# Liverpool Health and Academic Precinct

## Consultation Plan

PROJECT: Liverpool Health and Academic Precinct  
RE: SDRP SESSION 42 – 23.10.19 (first review)

PROJECT: Liverpool Health and Academic Precinct  
RE: SDRP SESSION 45 – 04.12.19 (second review)

DRAWING TITLE  
**FORBES ST ENTRY FORECOURT**

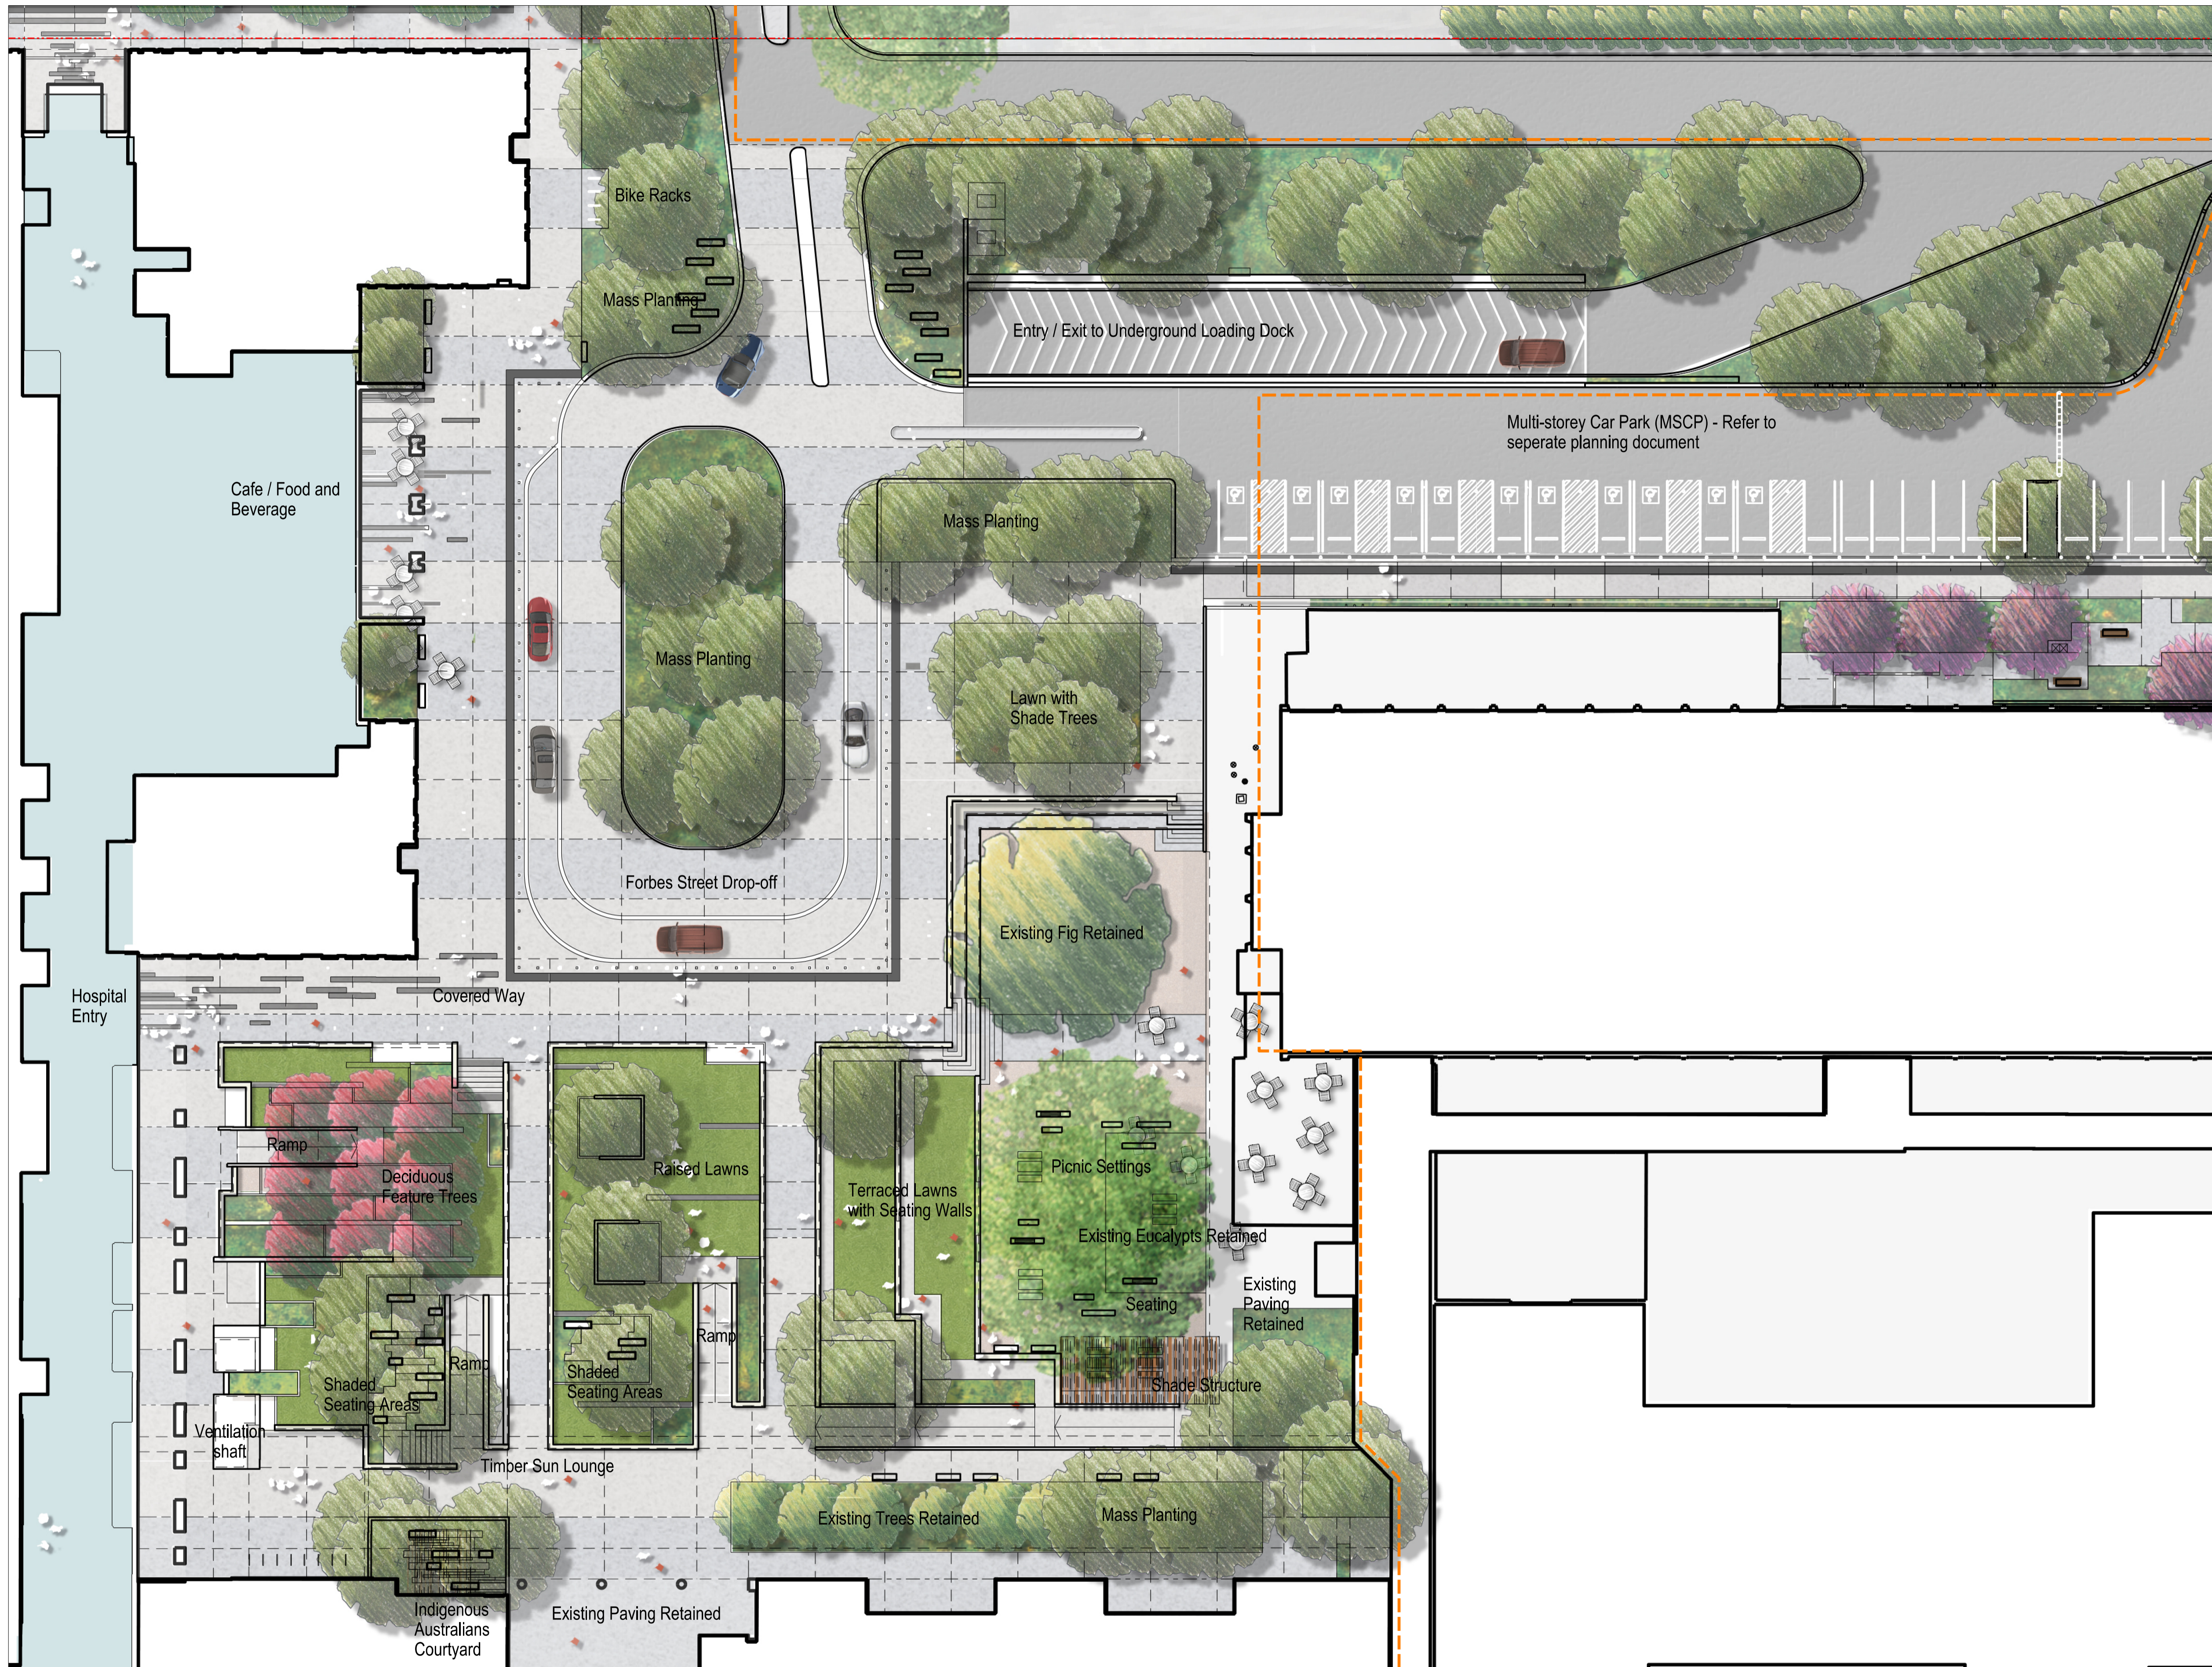
- Reinforce the idea of the landscape as driver of the masterplan by giving prominence to and privileging the proposed open spaces;
- The main open space north of the Caroline Chisholm building should be further developed with a larger landscape footprint, minimising drop-off areas and hard paving. Creation and maintenance of this open space is strongly recommended to futureproof the site in the context of future development envisioned to the east of the Caroline Chisholm building.

DRAWING TITLE  
**CAMPBELL ST SHARED WAY**

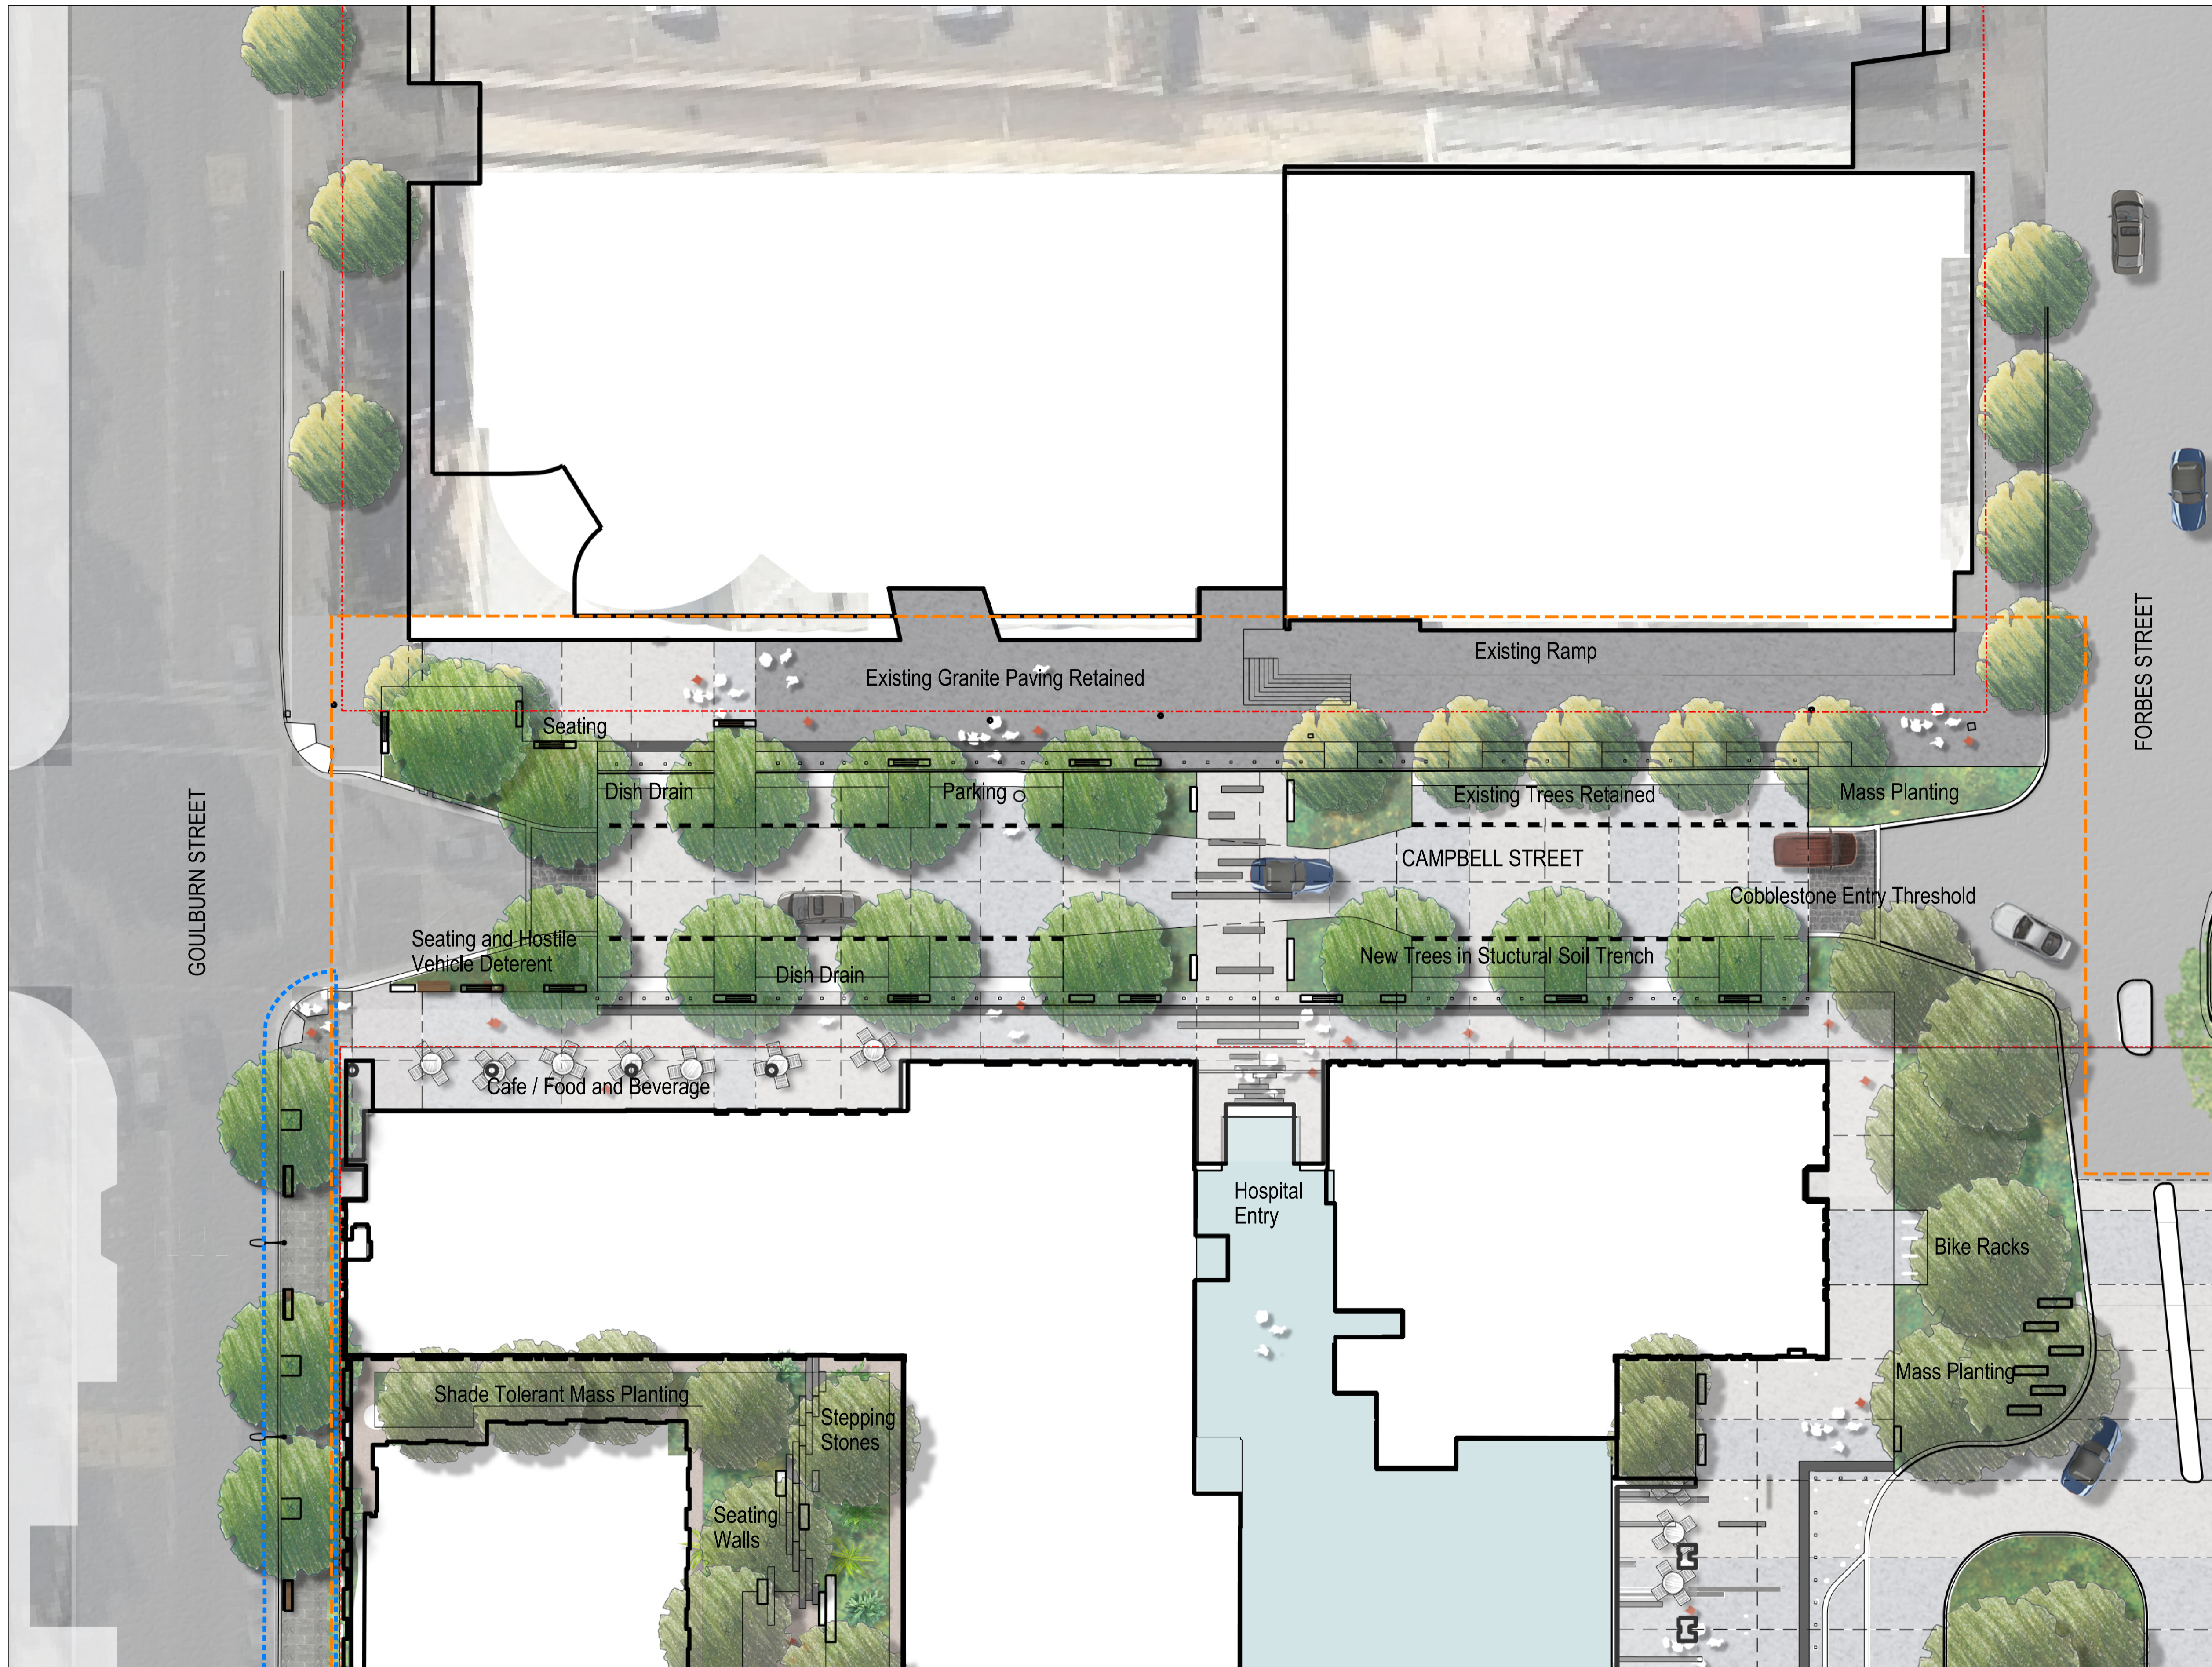
separate meeting to discuss their public domain and interface with the hospital landscaping. - A separate meeting to be organised to discuss traffic and shares zones on Campbell Street. - Council requires more details on the shared zone for the drop off area in Stage 2.	and traffic.  - The project developed the shared zone design and presented in the following meeting with council.
06/12/2019	Meeting with Liverpool City Council	Meeting held to address Public Domain / Landscaping.	Council would like to review tree removal plans and more information on traffic studies requested.	Project reviewed the possibility to remove the gum trees, however it was not possible due to the clinical space required within the IPU towers. Presented in the follow up council meeting on 05/03/20.
05/03/2020	Meeting with Liverpool City Council	Meeting to present latest Traffic and Public Domain Design.	- Council requested the project consider appropriate signage. - Council noted that the gum trees previously raised can be removed. Recommended to replace these with Brush Box species.	- Wayfinding consultant is engaged and will assist with signage as part of DD and Design Finalisation.  - Project updated drawings to consider Brush Box species.
